TPO Properties, LLC – 26 Ledgewood Drive - Request for preliminary subdivision approval for the 14-lot Old Barn Estates Subdivision. Tax Sheet 512; Map-Lot R04-068-E. Zoned RA and RCZO.

The applicant appeared before the Board in August 2012 for a pre-application sketch plan review for this project. The applicant is now applying for preliminary subdivision approval for the proposed 14 lot Old Barn Estates Subdivision located off Ledgewood Drive in Falmouth. The proposed subdivision consists of 12 new house lots, two existing house lots with residential structures already on them (one structure at 26 Ledgewood Drive and one at the corner of Ledgewood Drive and Ocean Avenue in Portland), and two open space lots consisting primarily of wetlands and stormwater facilities. The 12 new lots will be served by public water and private wastewater disposal systems. A homeowners association will be formed to maintain the two open space parcels, the stormwater management systems, and the landscaping/buffering located on private lots.

OLD BARN ESTATES
 1062 OCEAN AVENUE, PORTLAND, MAINE
LEACH FIELD FILL SLOPE DIAGRAM
 PROJ. NO. _____ REV. _____
 DWG. NO. _____

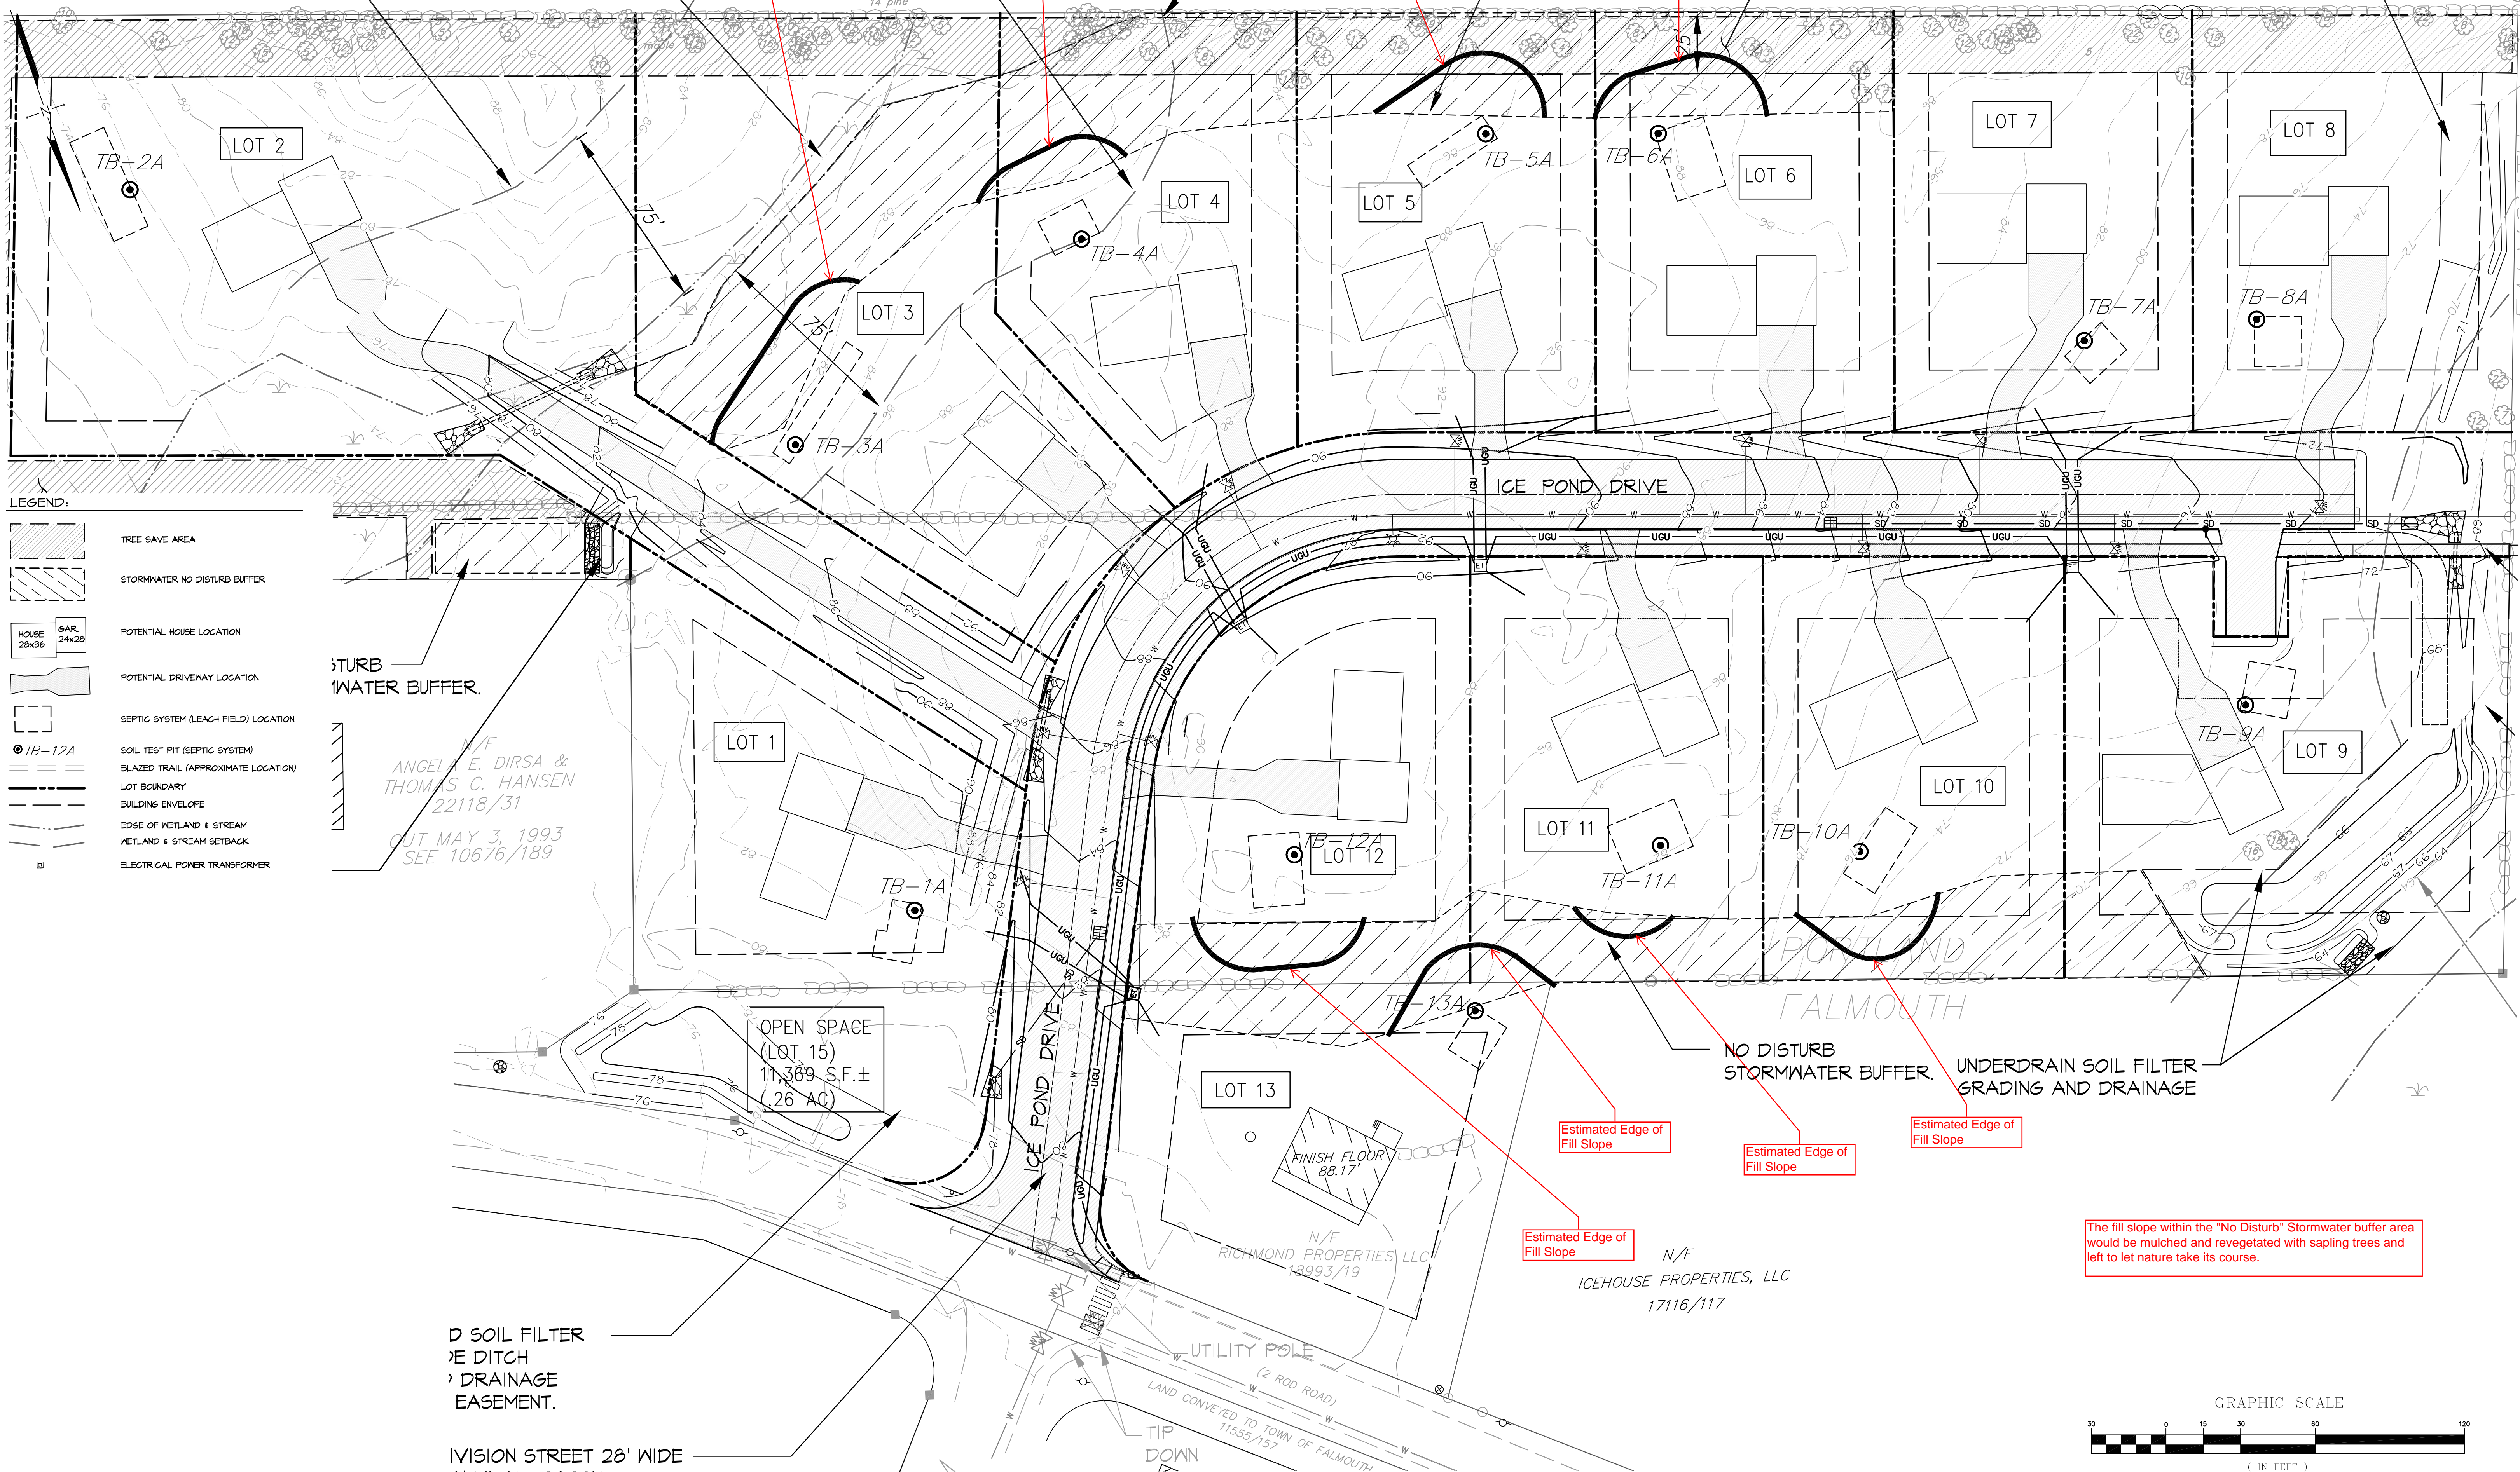
- Appendix 1(B) of the Subdivision Ordinance speaks to the preservation of trees >10" dbh. Open Space Lot 15 is currently heavily wooded but is being proposed to include an underdrained soil filter basin which will entail clearing much, if not all, of this area. The applicant is proposing to replant this stormwater area with eight "buffer trees" and two "street trees". One question is whether there are any opportunities to preserve any of the mature vegetation on this parcel to help retain the character of Ledgewood Drive along this stretch of road and to help buffer the stormwater area and the new house lots behind.
- A "no disturb stormwater buffer" is proposed along the back of Lots 9-12. This buffer will help screen the visual impacts of the development from Ledgewood Drive. How will these buffers be identified to prevent clearing abuses by future lot owners?

**OLD BARN ESTATES**  
 1062 OCEAN AVENUE, PORTLAND, MAINE  
**POST DEVELOPMENT DRAINAGE PLAN**

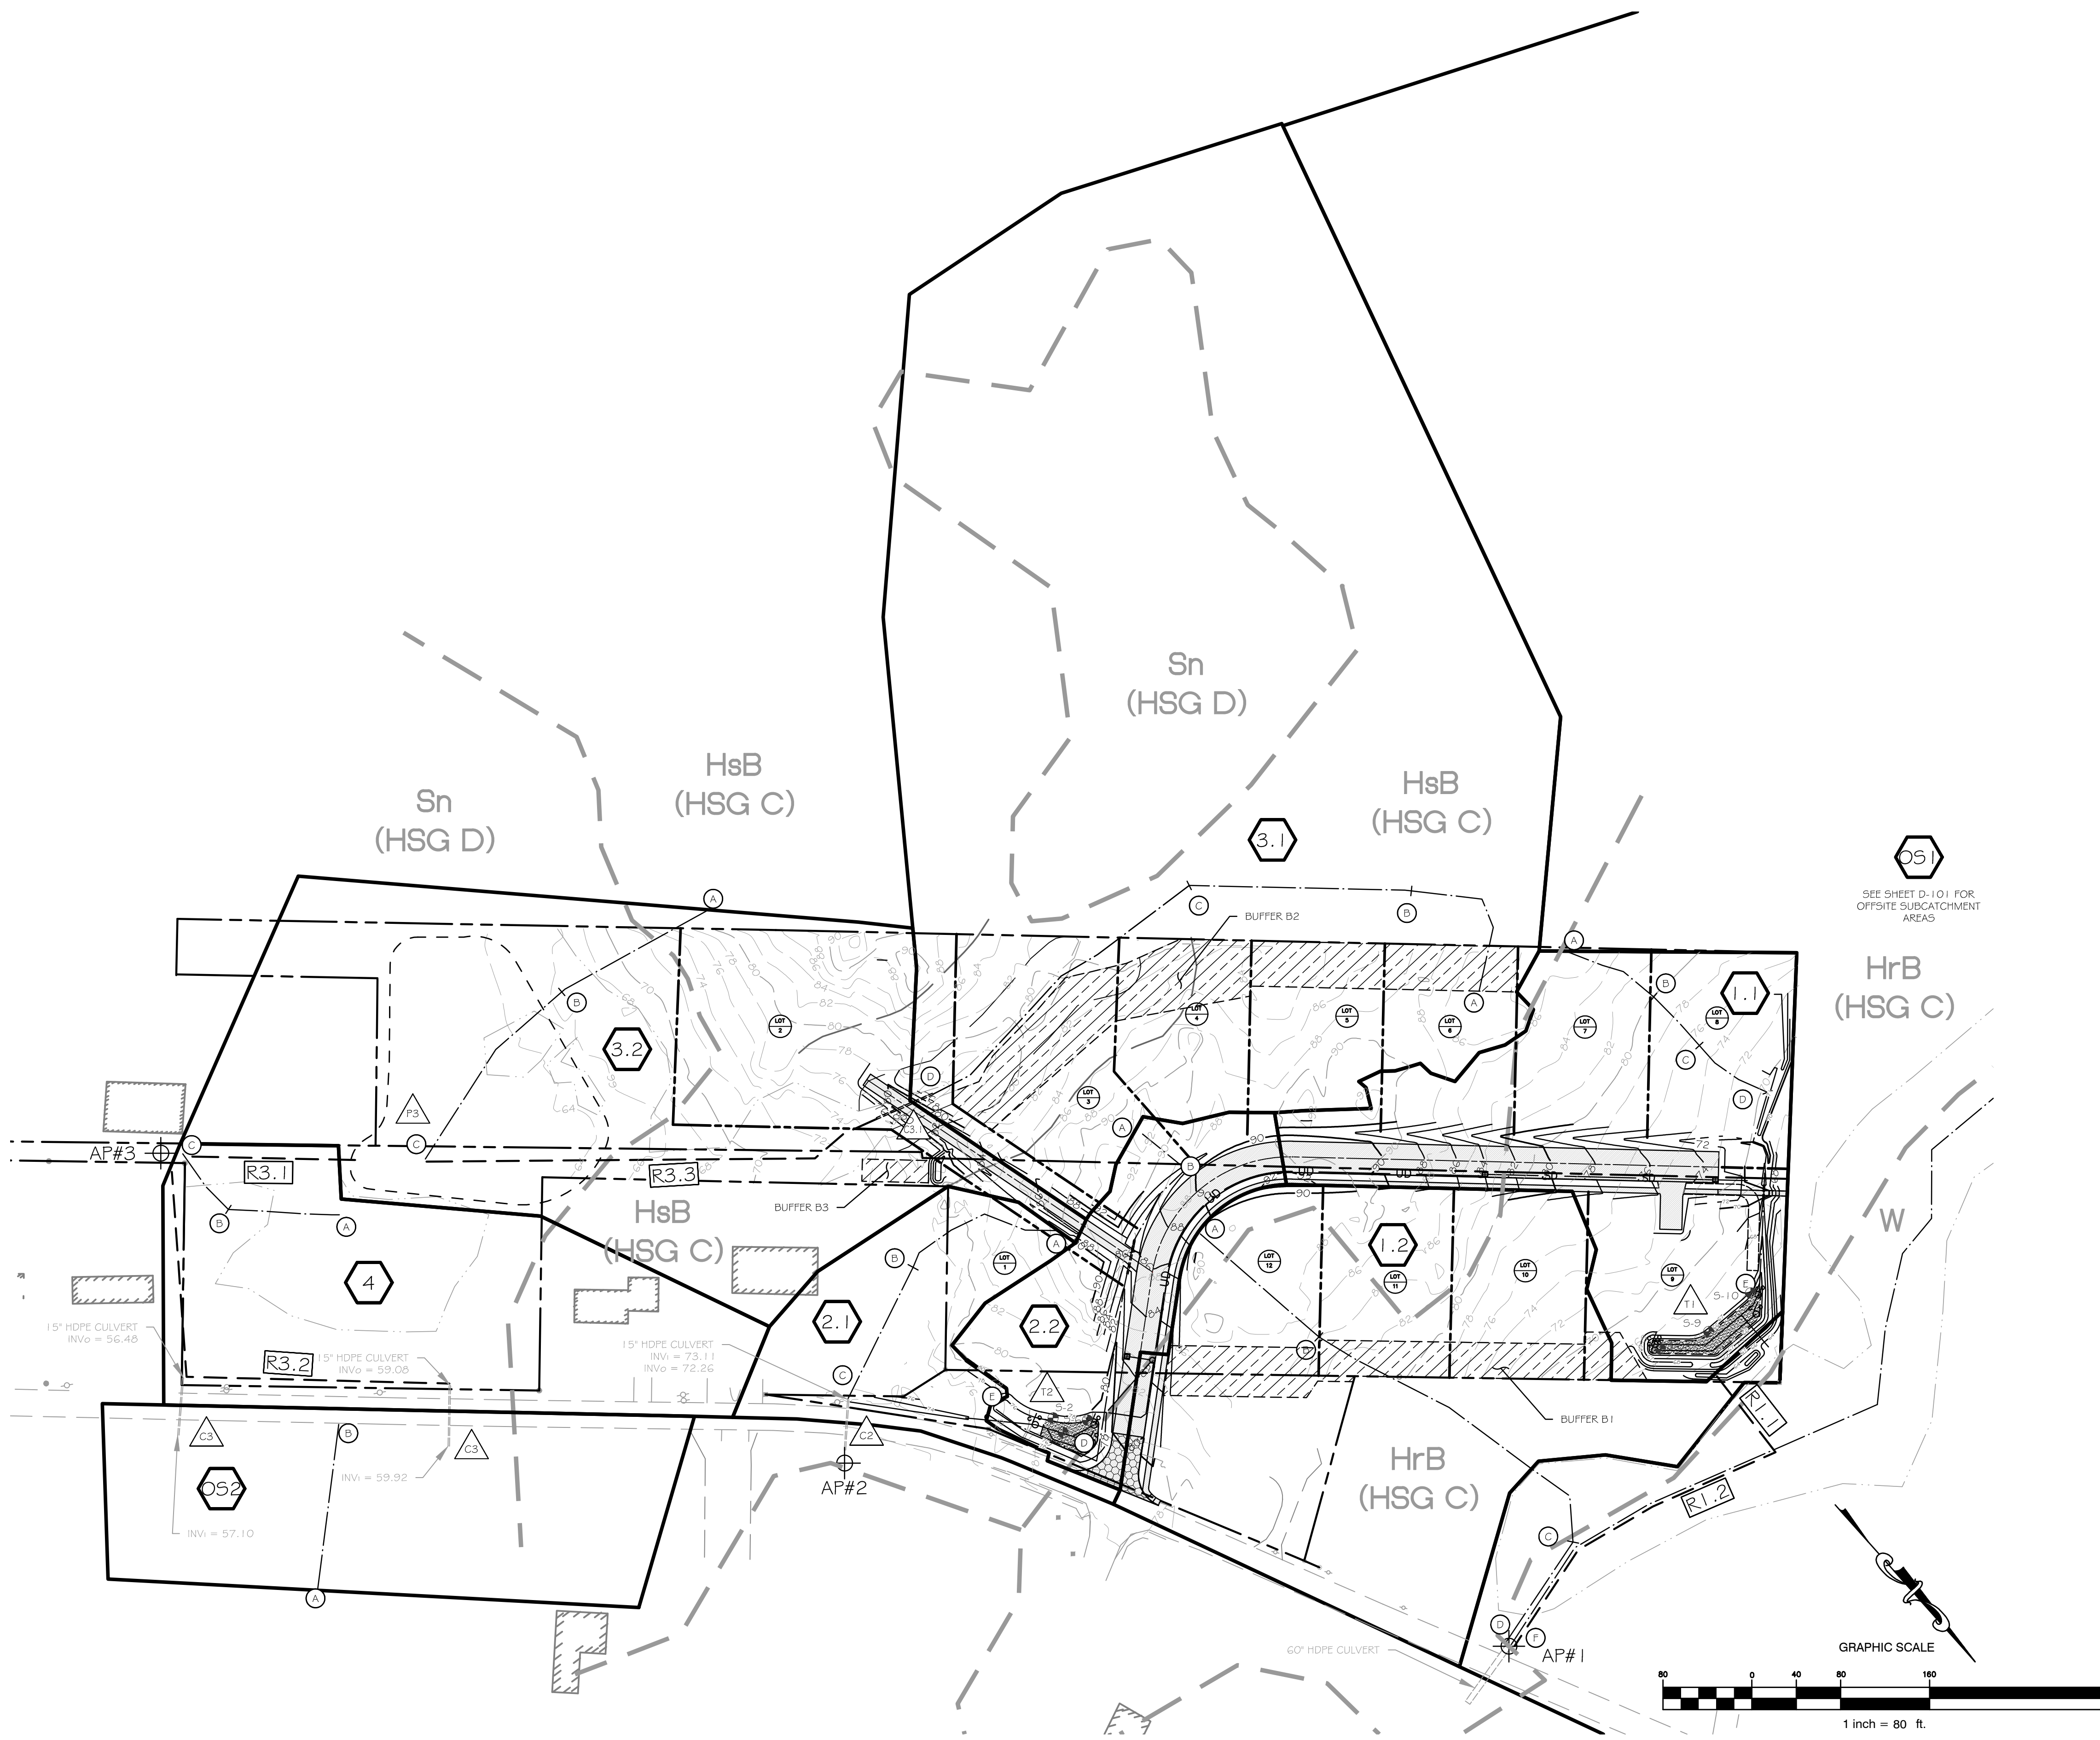
- One of the points of analysis (AP #1) used to compare pre- and post-development flows is located off-site at the existing 60" culvert under Ledgewood Drive. While there is some rationale for using this location as a point of analysis, especially since the flows are directed to an off-site wetland that is owned in part by the applicant and in part by the open space to the abutting Elm Landing Subdivision, the Subdivision Ordinance technically requires that an analysis be performed at the subdivision boundary. The Board should determine if it is comfortable with the analysis presented or if it would like the applicant to run the stormwater calculations for flows at the subdivision's property boundary.
